ENG-SP20003-R5-PDR.pdf Markup Summary

EXHIBIT 1 - GRADING CLOSE UP

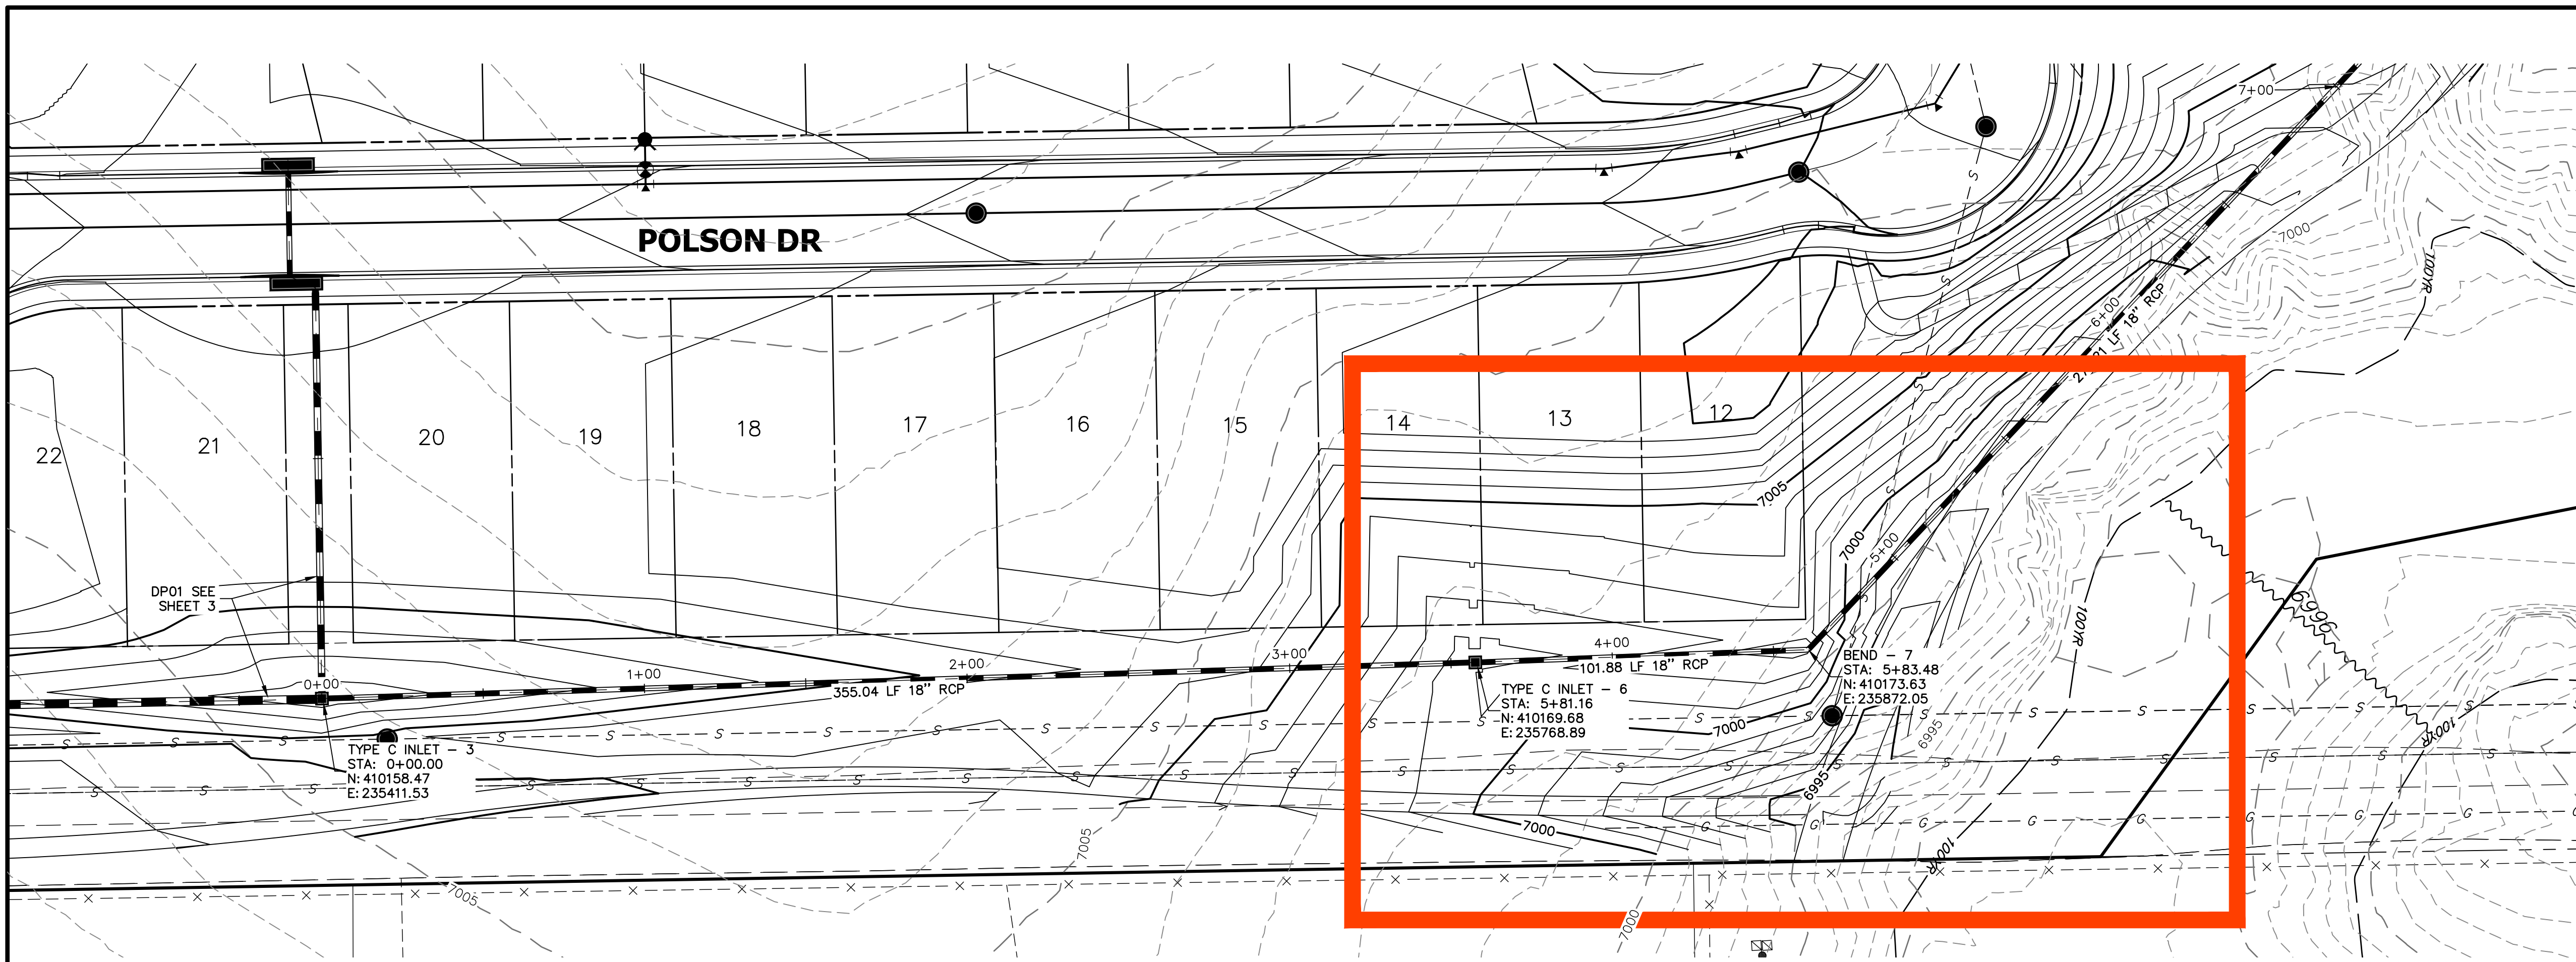
Construction easement needed

wall easement and maint. responsibilities need to be addressed on Prelim. Plan
